120-Day Temporary Building Certificate of Occupancy (C.O.)

Lindo Mexico Restaurant, [K-19/D144]

7209 Central Ave. NE

Grading & Drainage Plan

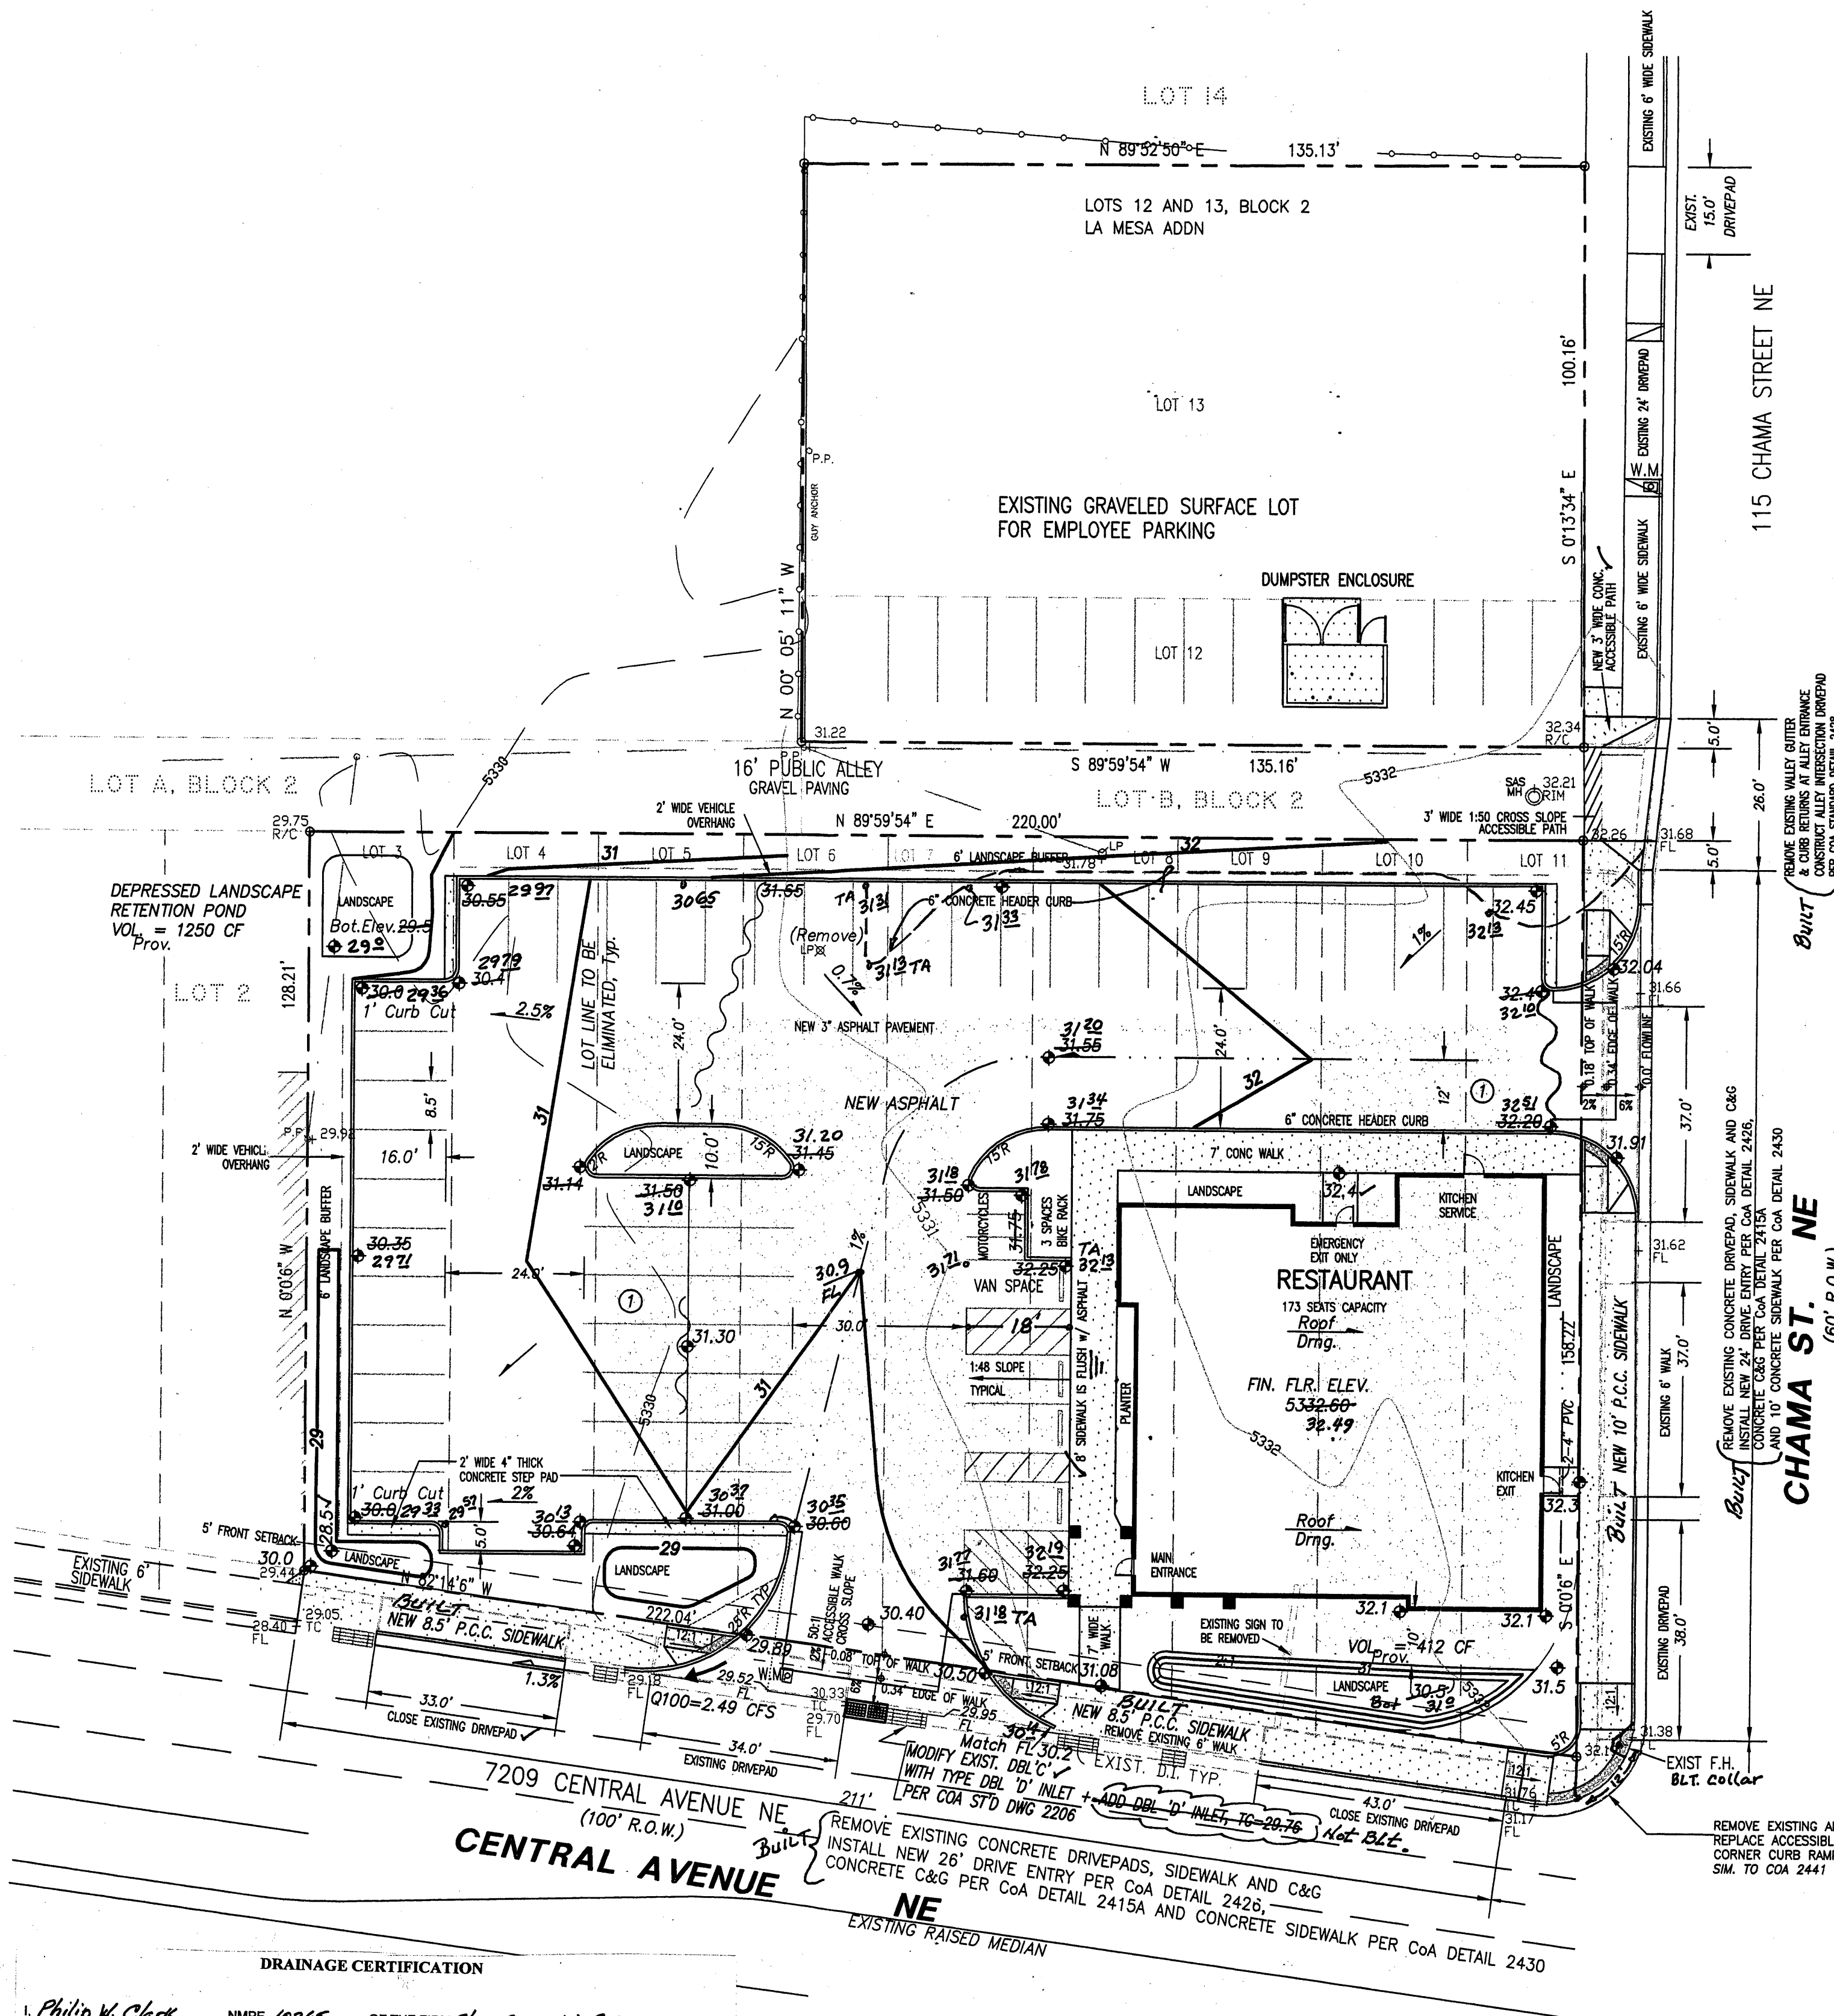
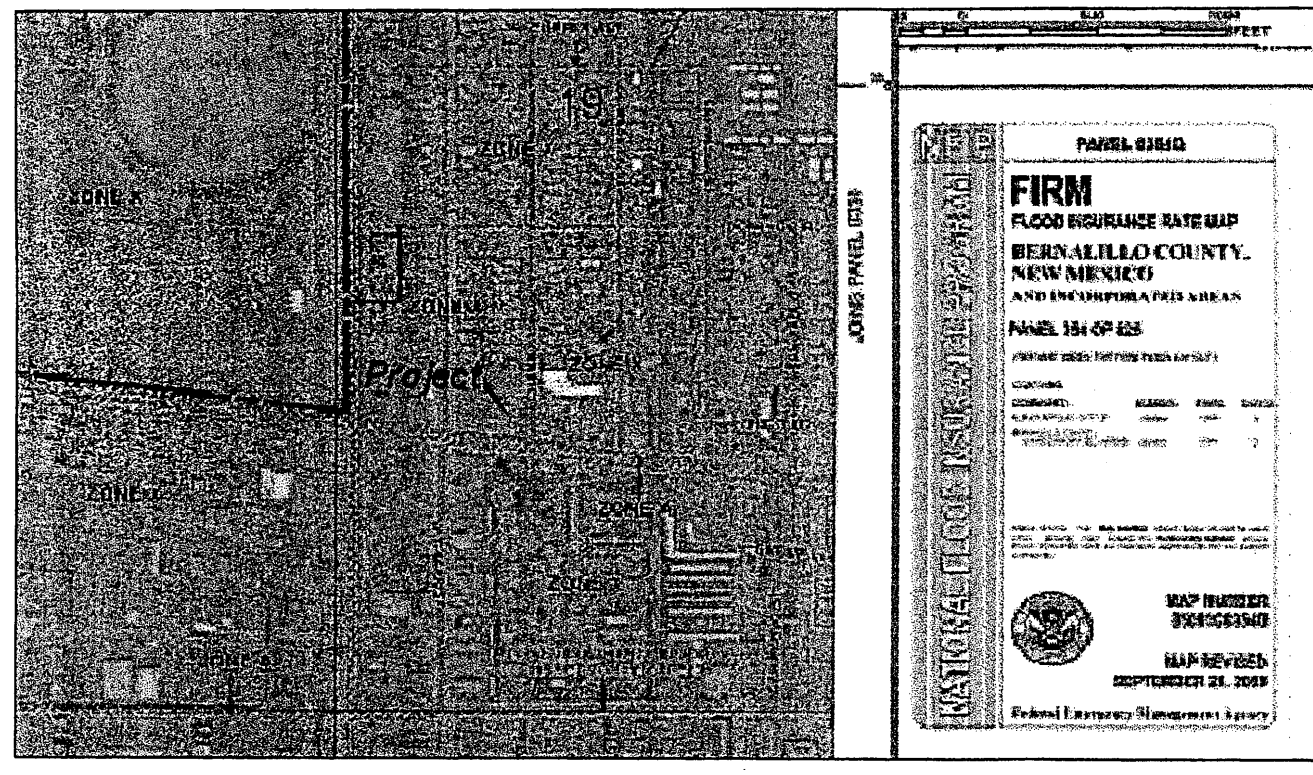
Based upon the information provided in your submittal dated 12-07-11, the above referenced plan cannot be approved for Building Permit until the following comments have been addressed:

• Type C inlet will need to be placed along Central Avenue.

- Once the landscaped areas fill with water where does the water go? Discharge over the sidewalks will not be permitted.
- Please provide hydraulic calculations showing the historic flows in the area along with your developed flows.
- Roof slopes on the new restaurant need to be shown on the drainage plan.
- The actual FIRM map needs to be displayed on the plan.
- No legal description for the lot was given on the drainage plan.

FILE # 1130CSITE
23 AUG 11

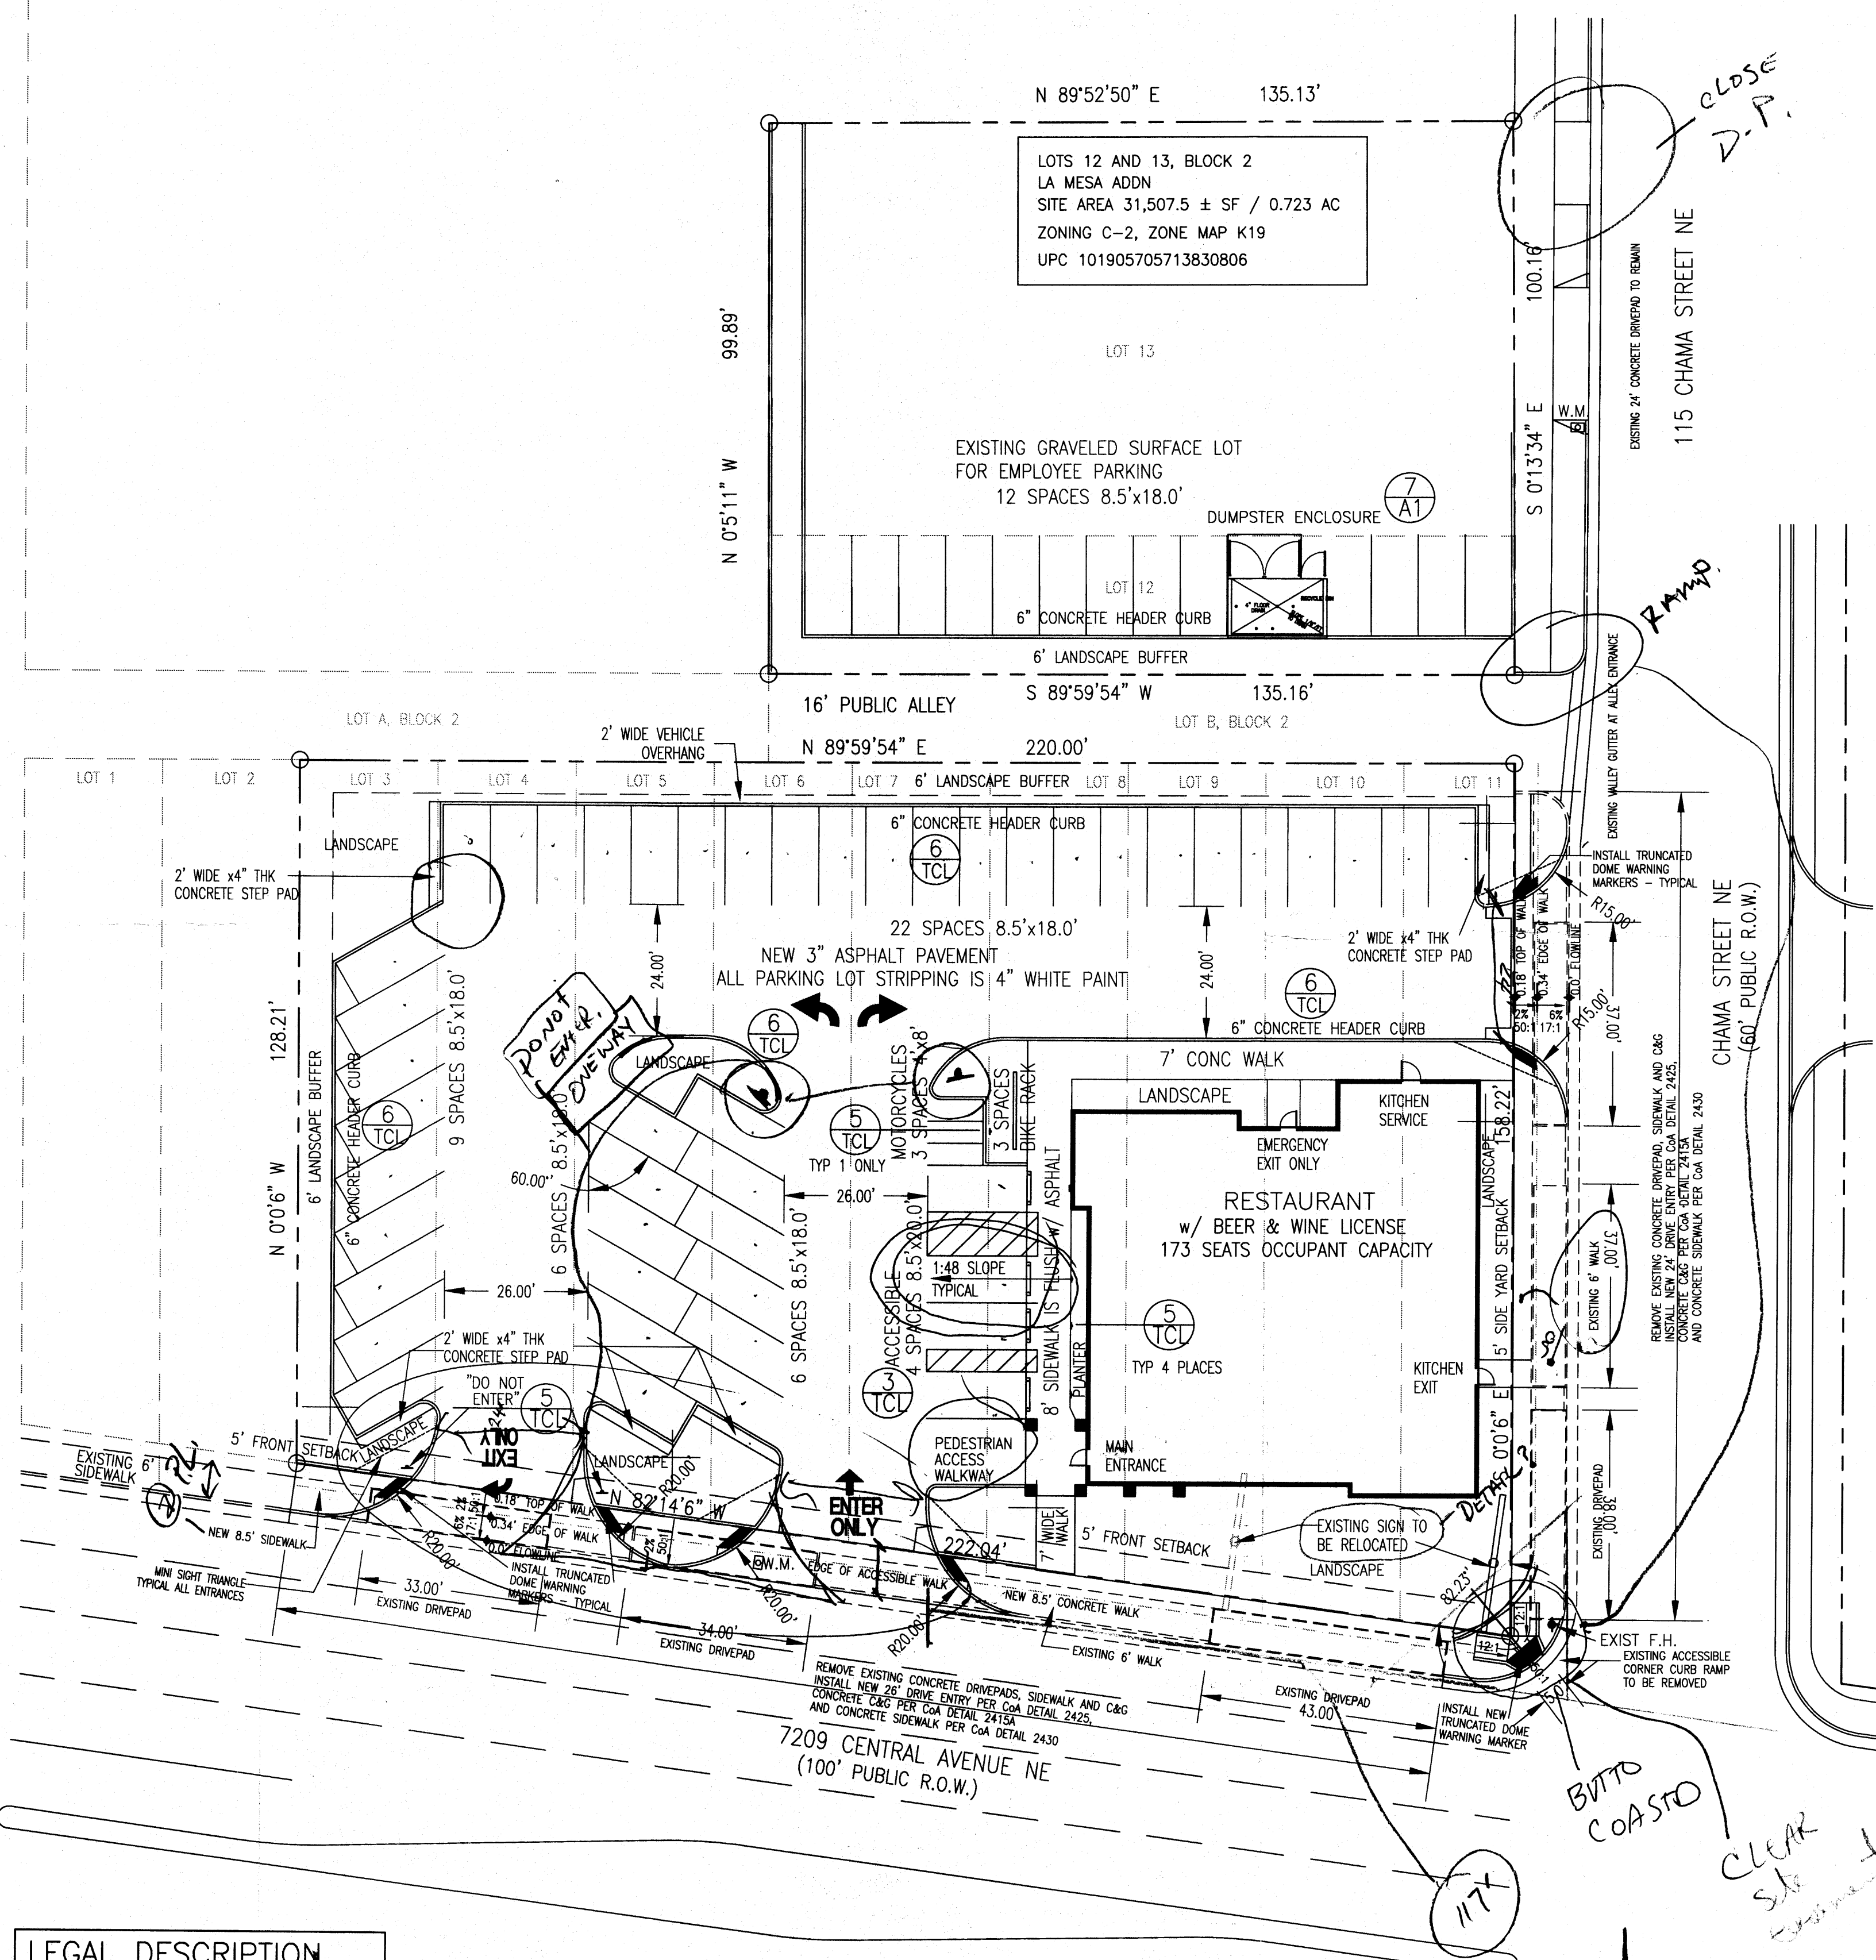
Based upon the information provided in your submittal received 11-21-11, the above referenced plan cannot be approved for Building Permit until the following comments are addressed:

1. Please clarify the status of the proposed platting action. What is the DRB project number? An approved preliminary plat must be provided prior to building permit approval.

2. Please show the revised lots lines per the proposed platting action.

3. It has been noted that existing conditions restrict the ramp at the corner of Central and Chama Street. Please clarify what conditions restrict this redesign. If the existing property lines are the restriction, this will be modified by the replat.

Item 1:

Replatting of the property to remove the internal property lines has been submitted to DRB for review and approval (Project #1009094, 12DRB-70107, 12DRB-70113).

Item2:

Property lines have been revised to reflect the replatting of the property.

Item 3:

The accessible curb ramp at the Chama / Central intersection has been revised with a 5' radius header curb at the back edge of the sidewalk ramp.
